**Application no: 22/01815/DISC**

**Location:** Land Approx 1 Mile From J9 East Of M40, Part Of M40 Through Chesterton Parish, Chesterton

## **Lead Local Flood Authority**

**Date: 18/08/2022**

Drawing title  
**Proposed Below Ground Drainage**  
Sheet 1 of 23

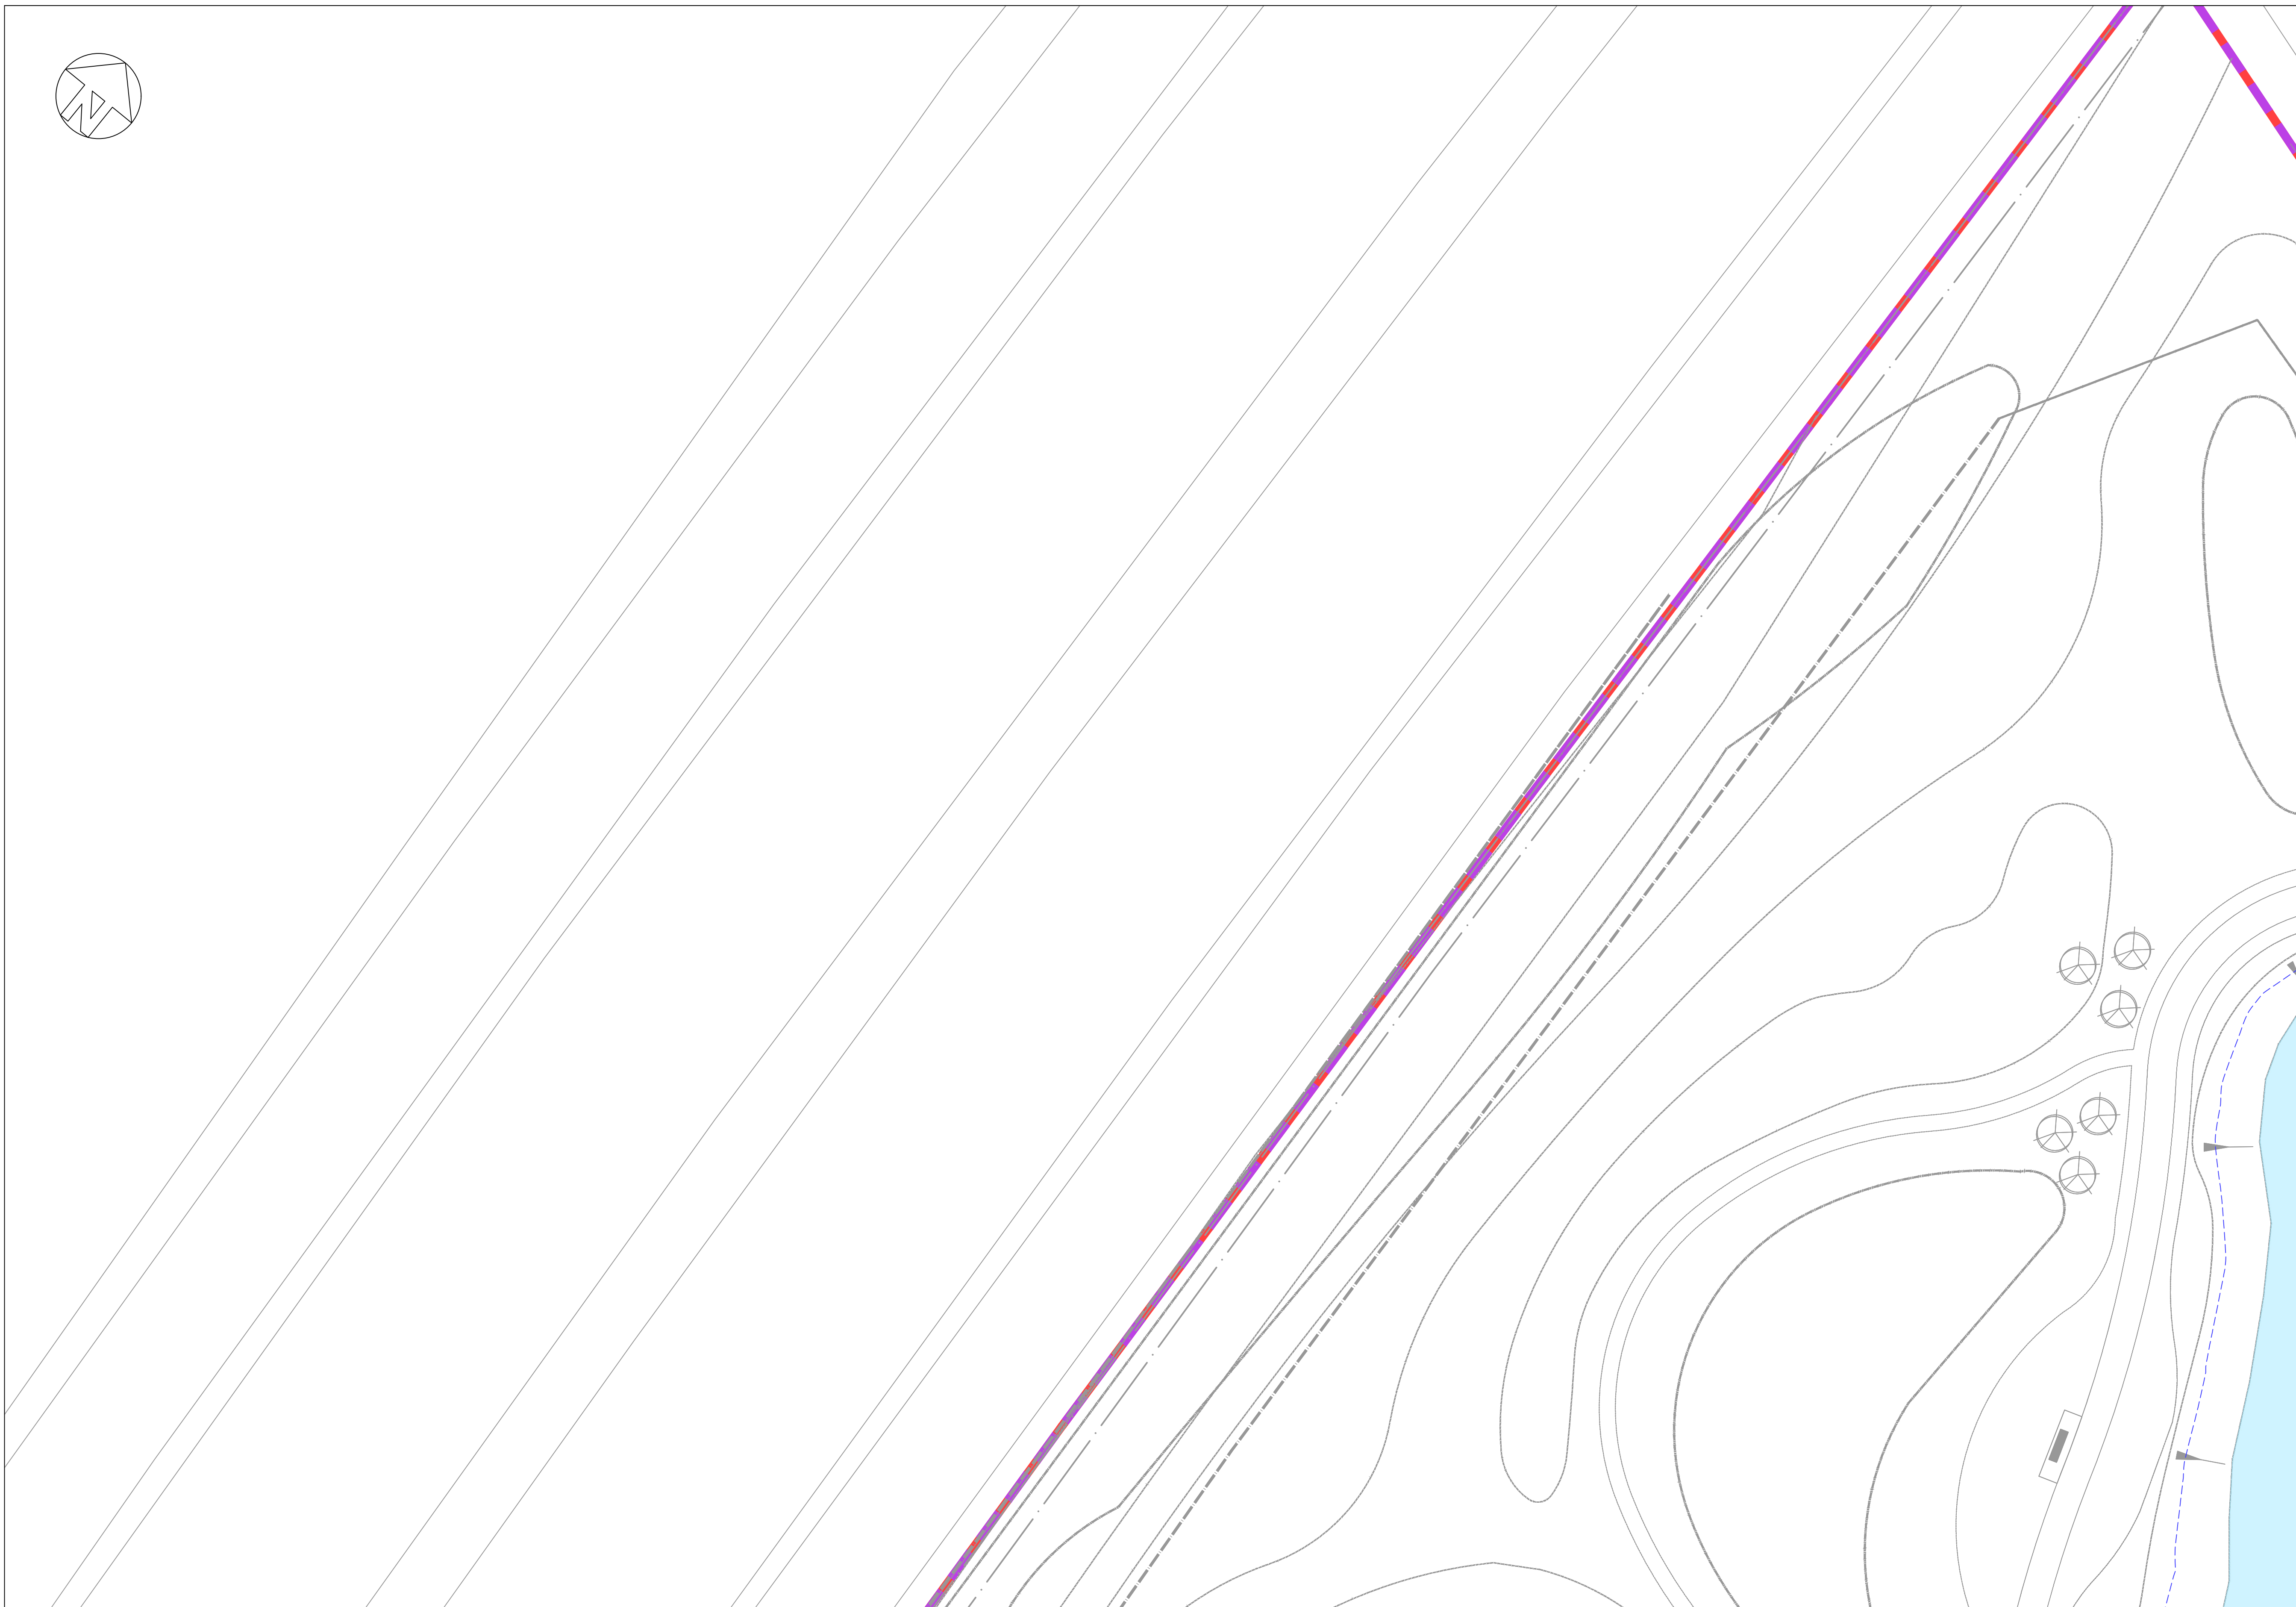
**Not all below ground drainage drawings are provided. There are 23 sheets, some sheets are not provided. Ensure all drawings are provided.**
